date August 21, 2017
 to Lauren Anderson, Planner; City of Mercer Island
 from Aaron Booy & Christina Hersum, ESA Biologists
 subject Hagstrom Review CAO17-004, Resubmittal

Environmental Science Associates (ESA) reviewed the Comment Response memo and revised mitigation plan sheet set (The Watershed Company [TWC], July 27, 2017) submitted to the City for the development proposal at 7428 SE 71st Street in Mercer Island, Washington. The project proposes demolition and rebuild of a single-family residence on Parcel 5368000300. ESA has previously reviewed Critical Area Study, Hagstrom Residence: Watercourse Buffer Reduction (CAS) (TWC, 2017) and the Hagstrom Residence Site Plan (Sturman Architects, 2017) for the project, most recently in our June 8, 2017 letter. The purpose of our review was to verify development proposal (CAO17-004) consistency with City Critical Areas requirements (Mercer Island City Code [MICC] Chapter 19.07), including response to our previous recommendations and confirmation that proposed mitigation measures adequately achieve the standard of no net loss of ecological functions.

## DRAINAGE PLAN

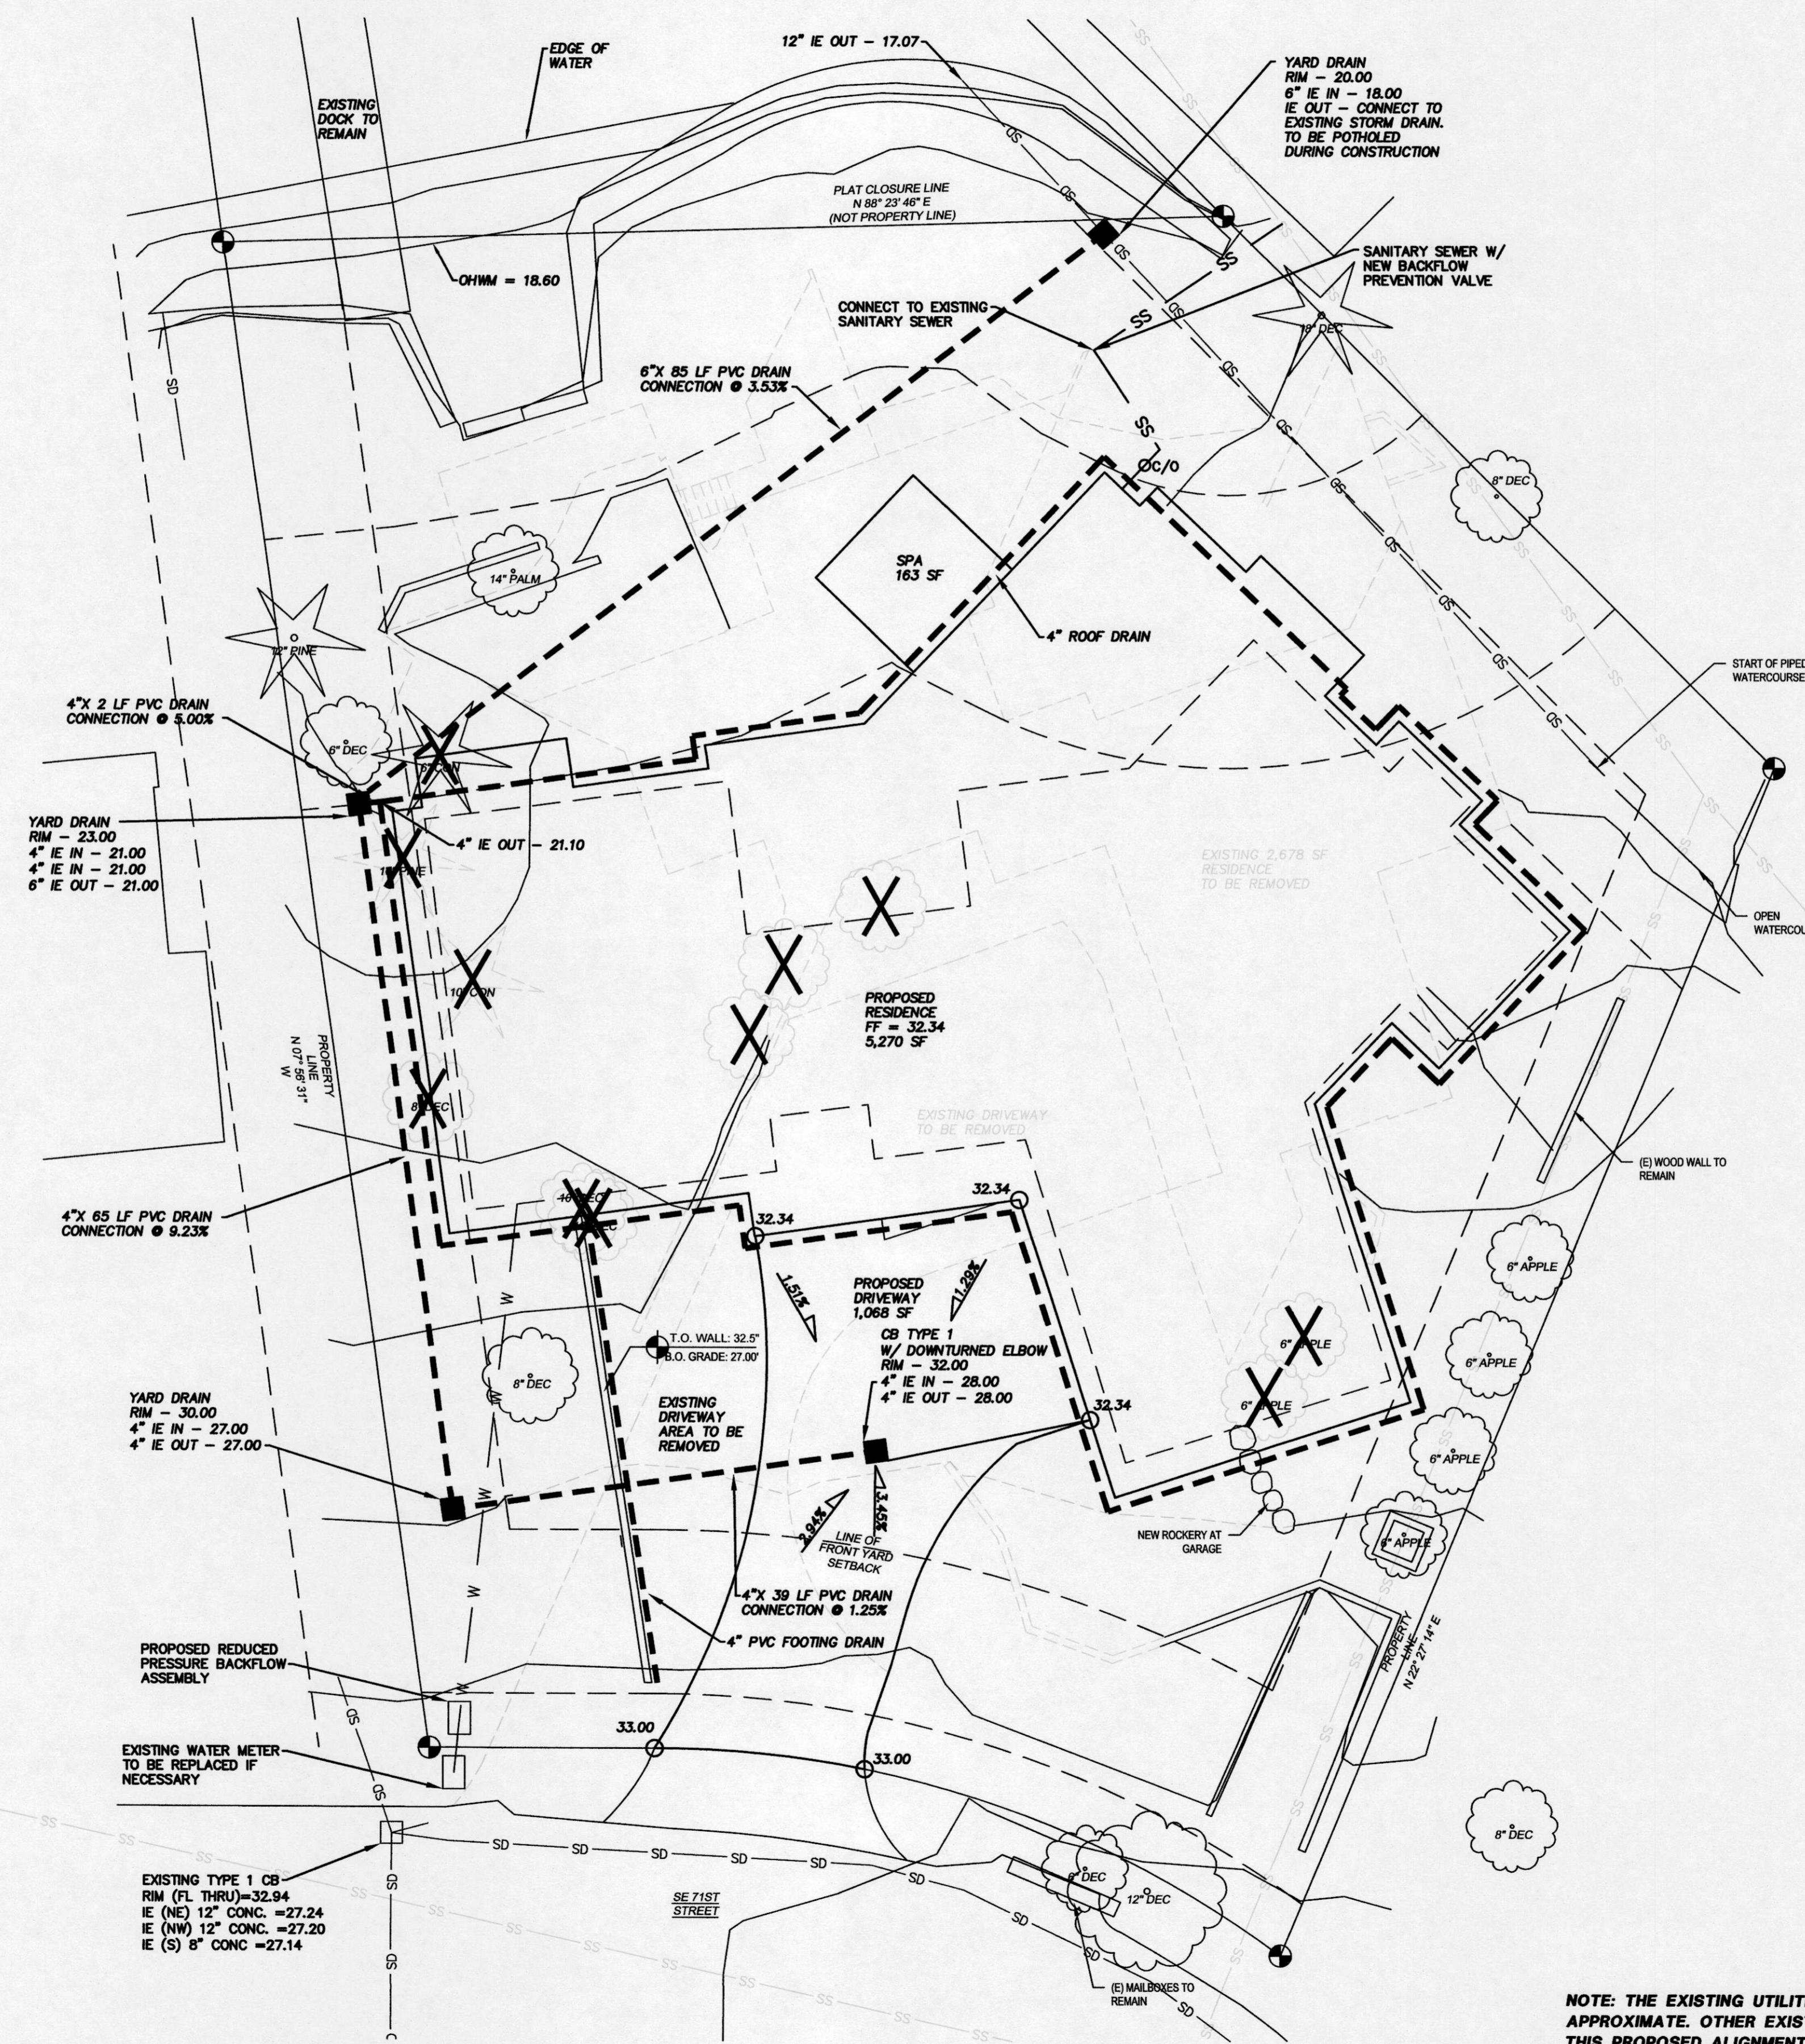
In addition to the recommendations above, we also recommend that the CAS be revised to include a discussion of the proposed storm drain catch basins and conveyance located within the reduced piped watercourse buffers and discharging to the piped segment of Watercourse A immediately above Lake Washington (per Engineering Drainage Plan [Eastside Consulting Inc., June 2017] provided by the City). While new utility facilities (including drainage conveyance and outfalls) may be allowed by MICC 19.07.030(7) (New Utility Facilities), the City requires mitigation and use of best management practices to the greatest extent reasonably feasible so there is no net loss in critical area functions. We recommend that the applicant be required to address potential impacts from proposed drainage facilities, and to provide mitigation consistent with MICC 19.07.030(7). Based on our review of submittal materials, we recommend options focused on reducing the amount of runoff from pollution generating impervious surfaces (the driveway), and/or providing basic water quality treatment for runoff. Potential options include the use of pervious materials for the driveway, or providing a vegetated bioswale in the conveyance flow path.

SHEET NUMBER:  
W3 OF 7

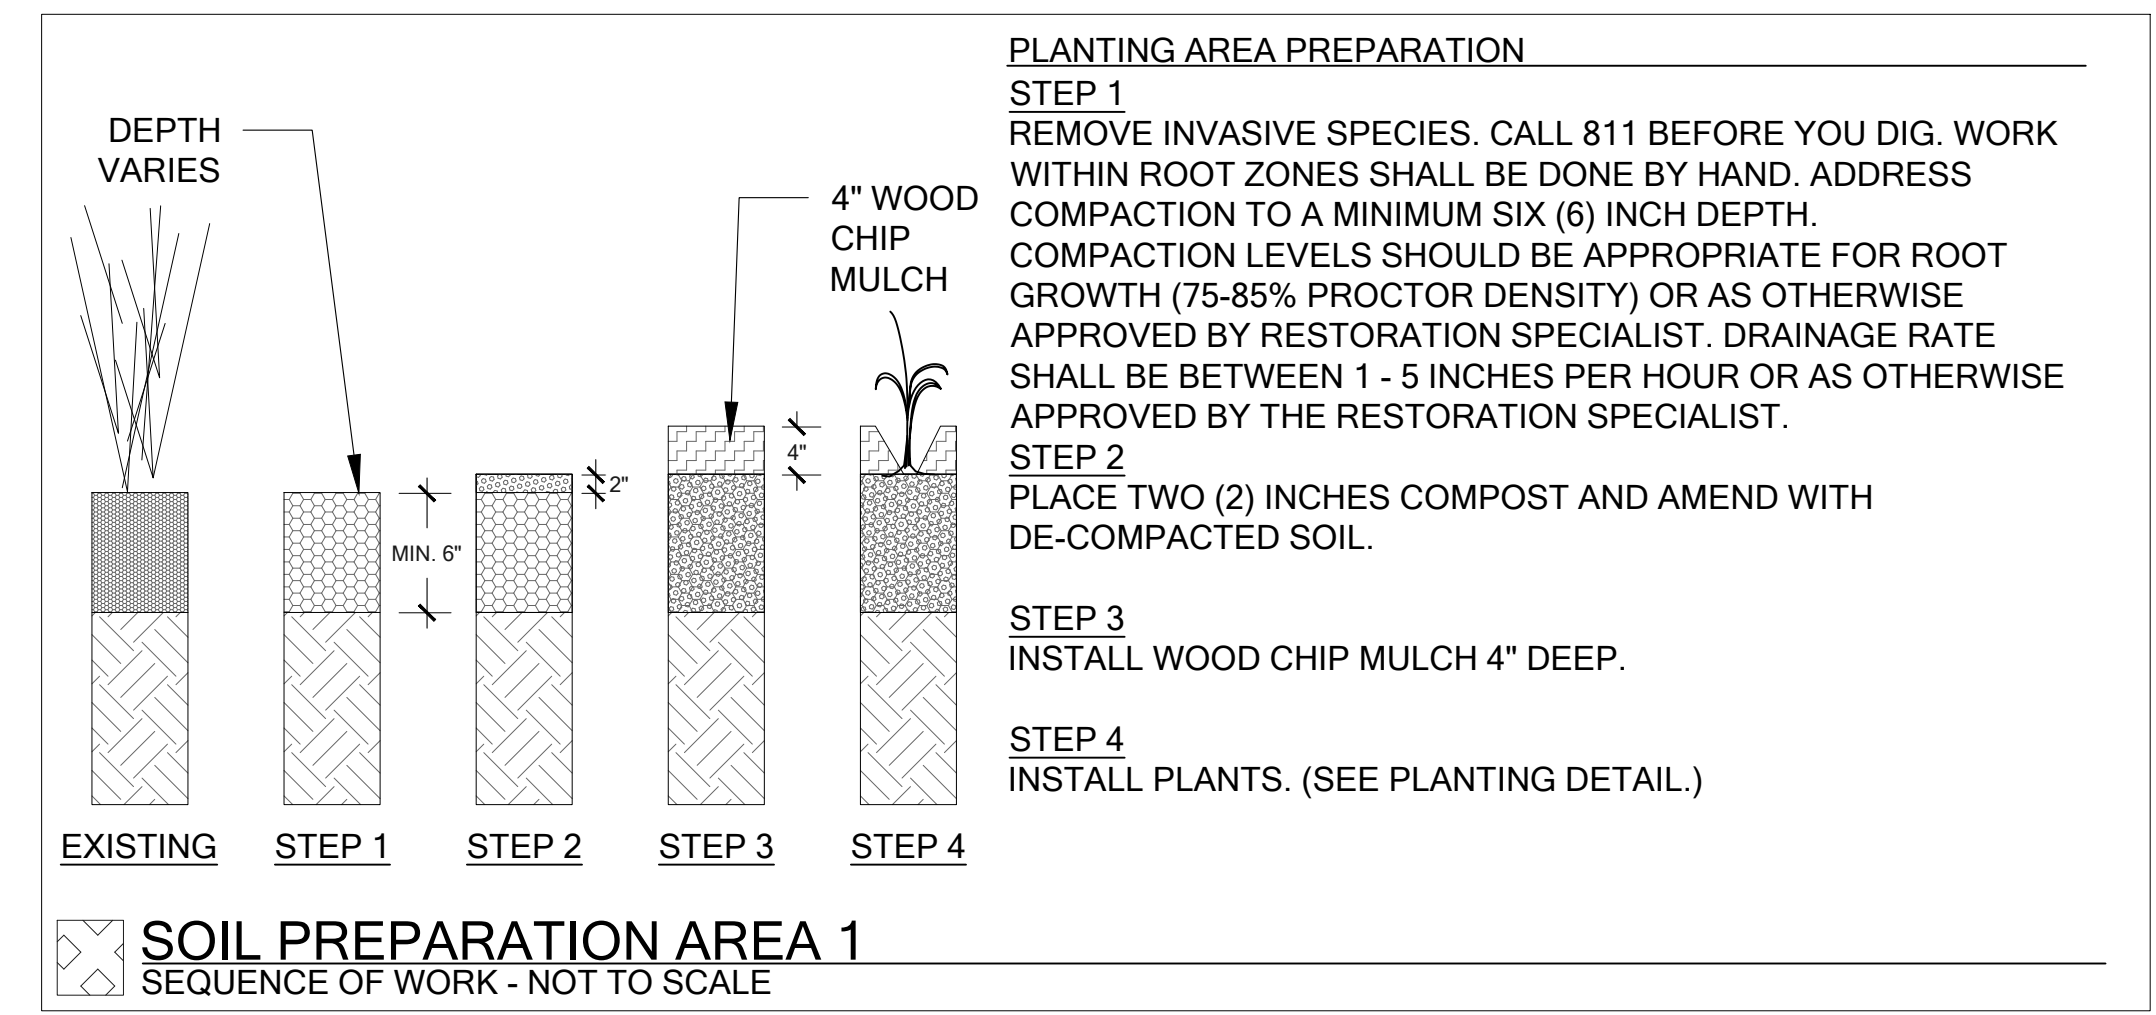
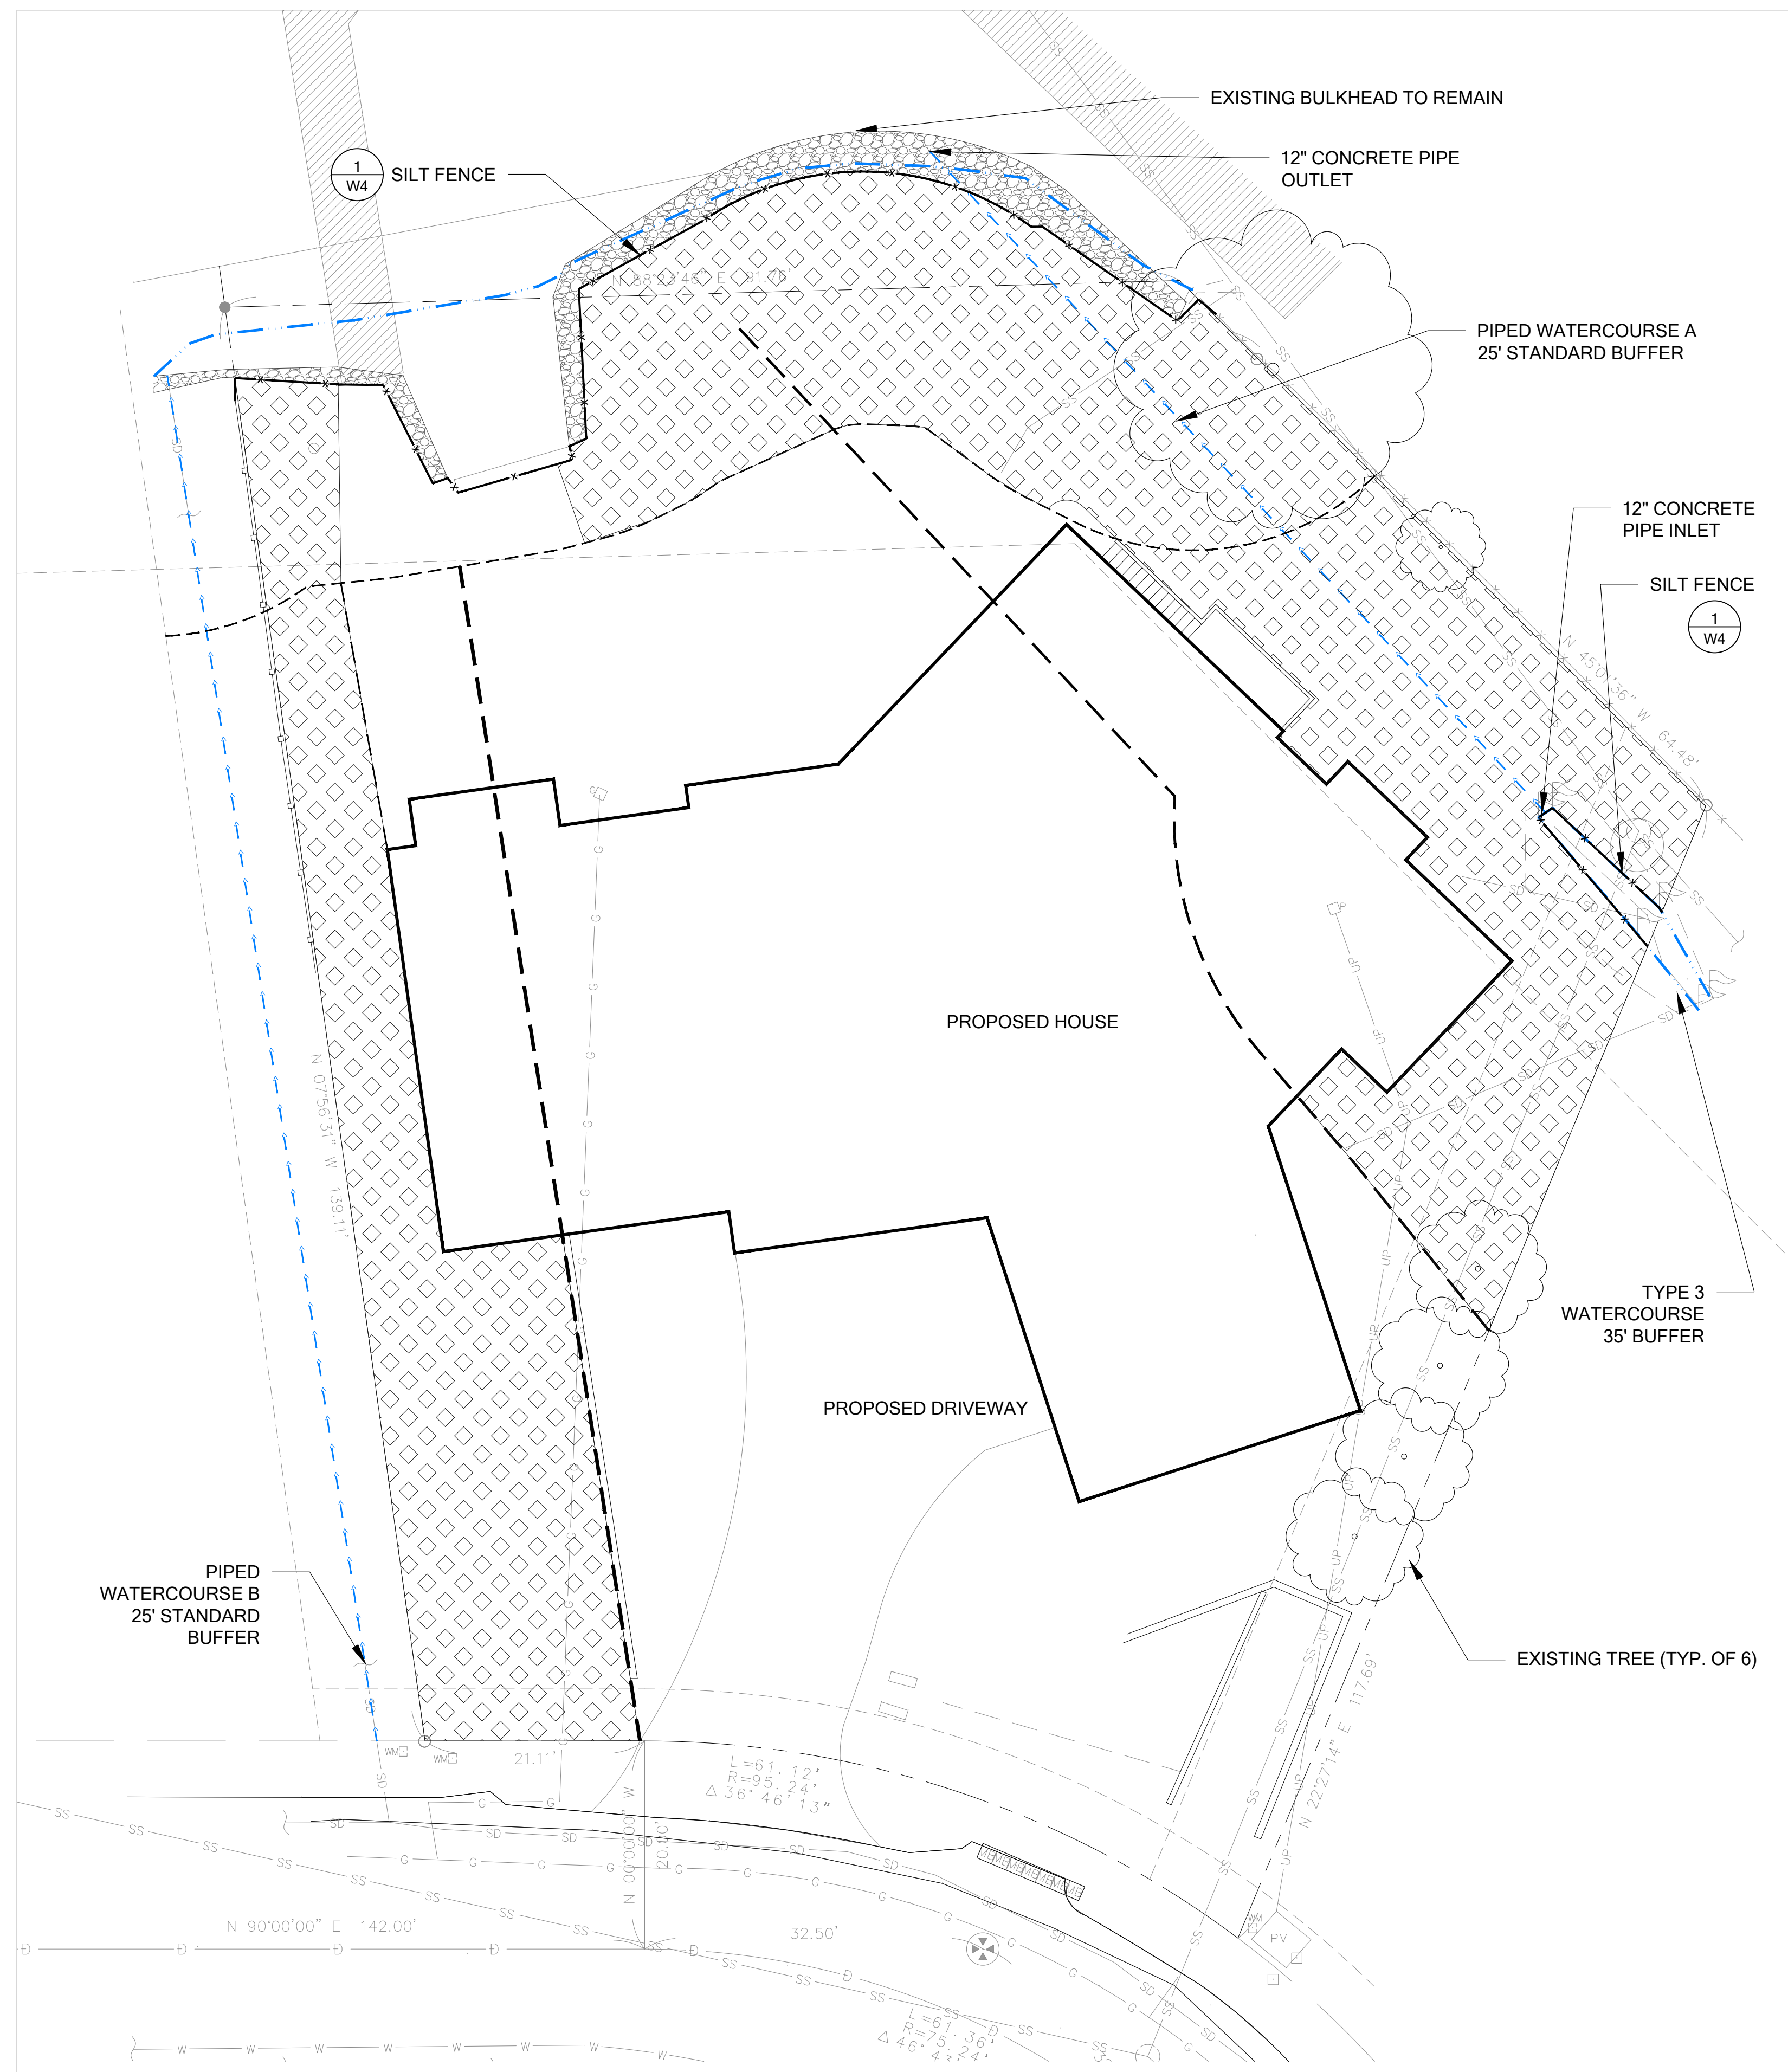
Recommendation 3	
List and indicate the minimum buffers for the piped portion of Watercourse A.	The mitigation plan sheets have been updated to include minimum distances between the proposed improvements and Watercourses A and B, as well as minimum buffer widths for Watercourse B.
Consider opportunities to provide 5-foot minimum buffer if not daylighting Watercourse A. This should include, at a minimum, realignment of stairway on east side of the proposed structure.	The mitigation plan sheets has been updated to include reconfiguration of the stairway so that it is now located further away (twelve feet) from Watercourse A.
Recommendation 4	
Correct inconsistencies between the drawing set and the CAS for the enhancement area quantity for the shoreline setback.	The Comment Response Memo states that the CAS has been updated to correct the inconsistency.
Correct inconsistencies between the drawing set and the CAS regarding the number of shrubs in the planting schedule.	The Comment Response Memo states that the CAS has been updated to correct the inconsistency in number of shrubs.
